Woodgate Nurseries and Adjacent Land
Proposal for up to 130 residential dwellings

Technical Note in Response to Network Rail Comments

(2401/TN/08)

January 2025

Figure 3.2 – Approved footway and cycleway improvements on the A29

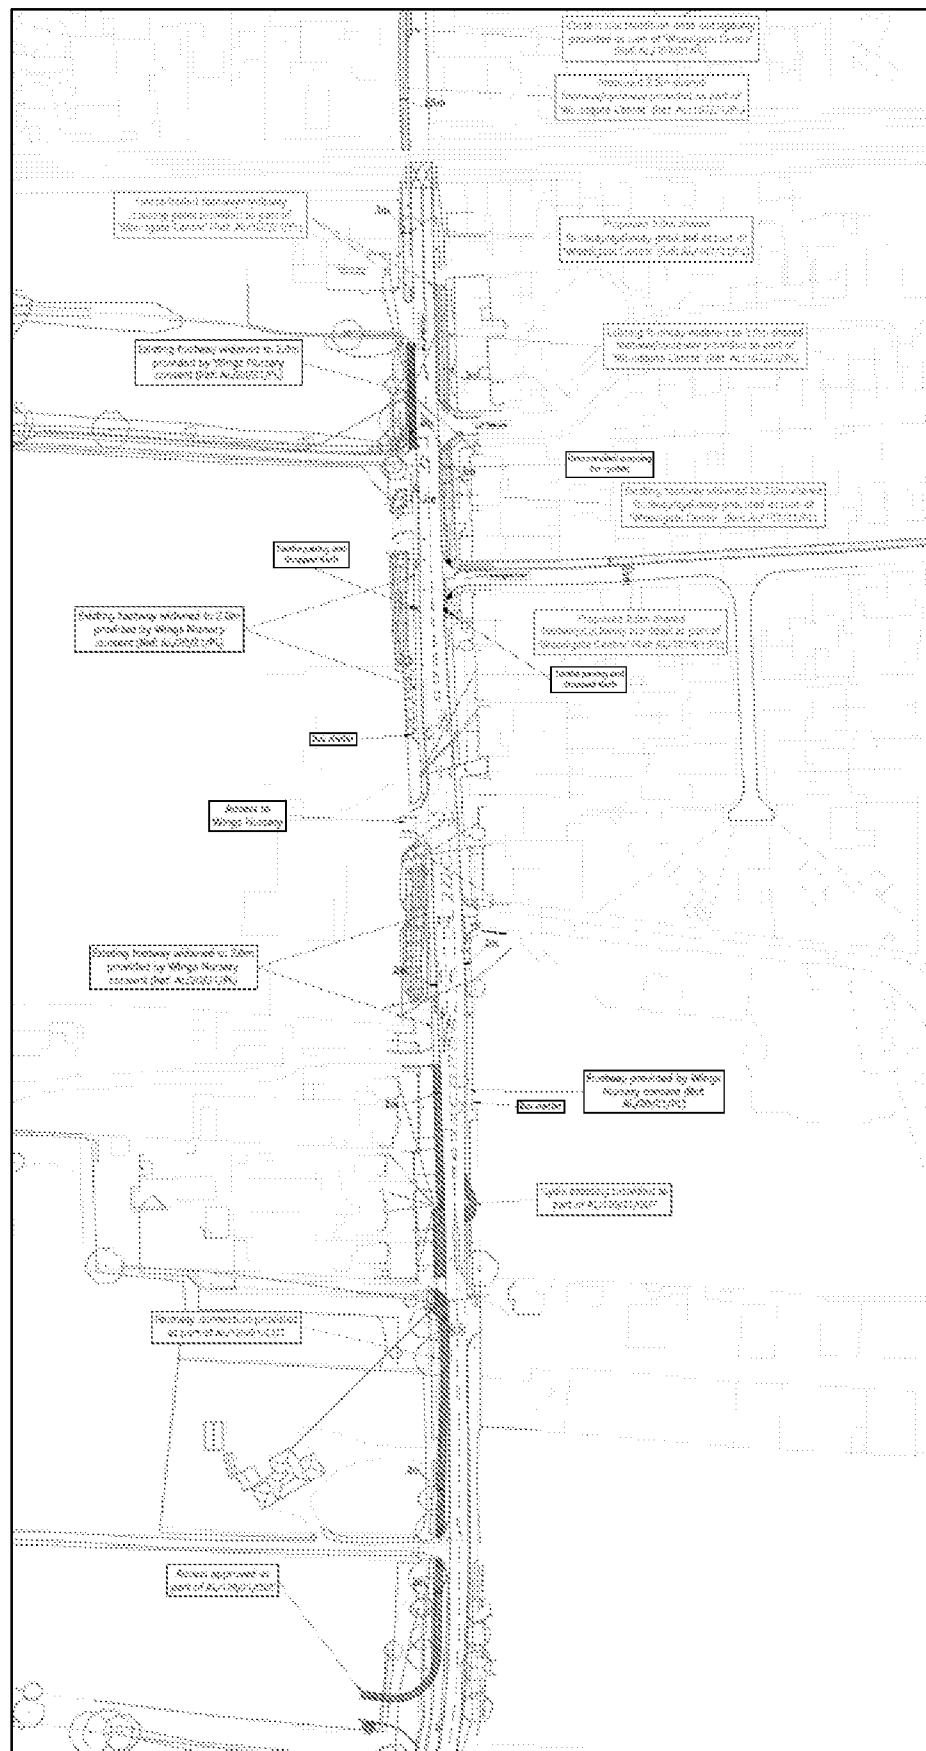
2.15 The pedestrian and cycle connections on the A29 and within the vicinity of the site are shown on drawing HTP/2401/09/A, contained in **Appendix 3**, with an extract of the drawing showing the approved works at the level crossing shown in **Figure 2.1**. The cumulatively approved works are summarised below:

- i. A new section of footway on the eastern side of Lidsey Road south of the Willows Caravan Park access
- ii. Widening of existing footways to 2.0 metres
- iii. Upgrades of footways to shared use footway/cycleways, with associated widening and the inclusion of kerbs
- iv. New pedestrian and cycle crossing points

2.16 Given that the existing pedestrian infrastructure will be improved to provide wider footways/cycleways, and that the existing footways will be kerbed, it is considered that the approved works will provide an improvement to the existing infrastructure.

Pedestrian/Cycle Access (HTp/2401/04/C)

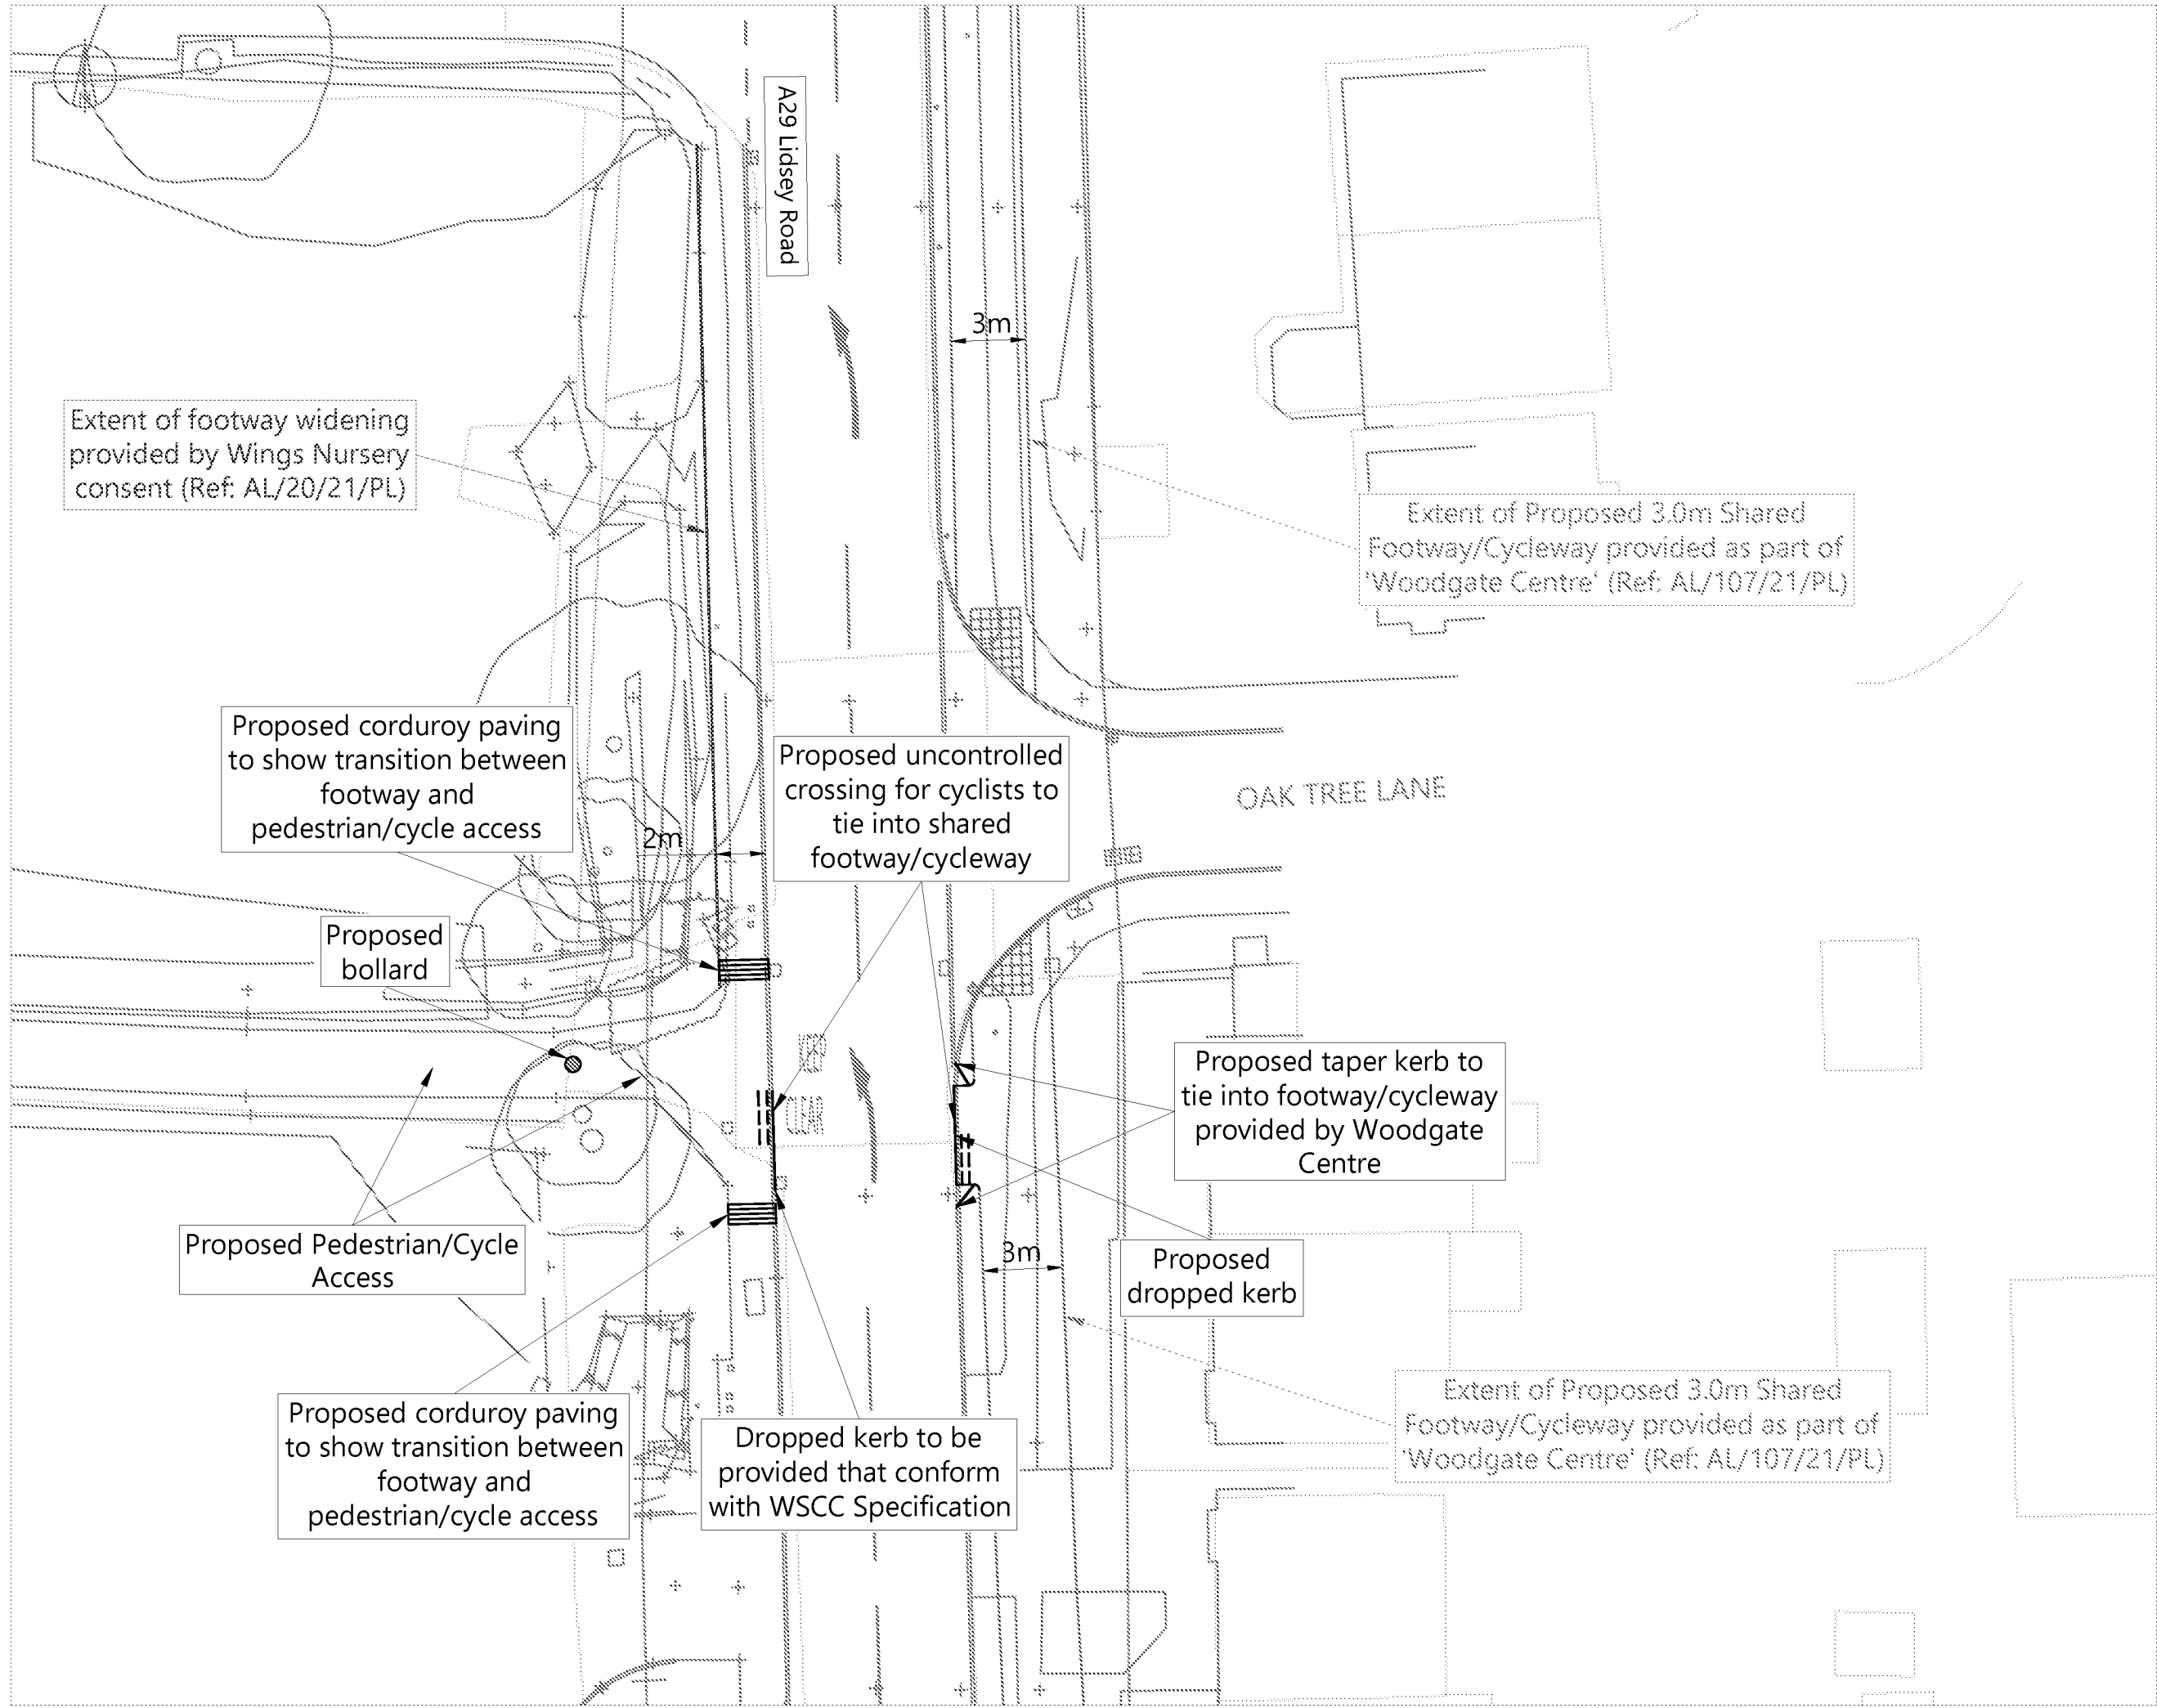
2.17 As part of this planning application, it is proposed to provide a pedestrian/cycle connection from the site to Lidsey Road which will tie into the 3.0 metre wide footway/cycleway provided by the Woodgate Centre application. The proposed connection is shown in **Figure 2.2**, for reference.

2.18 Given the approved footway and cycleway improvements on Lidsey Road, it is considered that the proposed development will be able to tie into these works, which provides a benefit to pedestrians and cyclists associated with the proposed development.

2.19 An Independent Stage 1 Road Safety Audit was carried out as part of the Transport Assessment works, to review the proposed pedestrian/cycle access shown in **Figure 2.2**. The Road Safety Audit and Designer's Response was accepted by WSCC Highways.
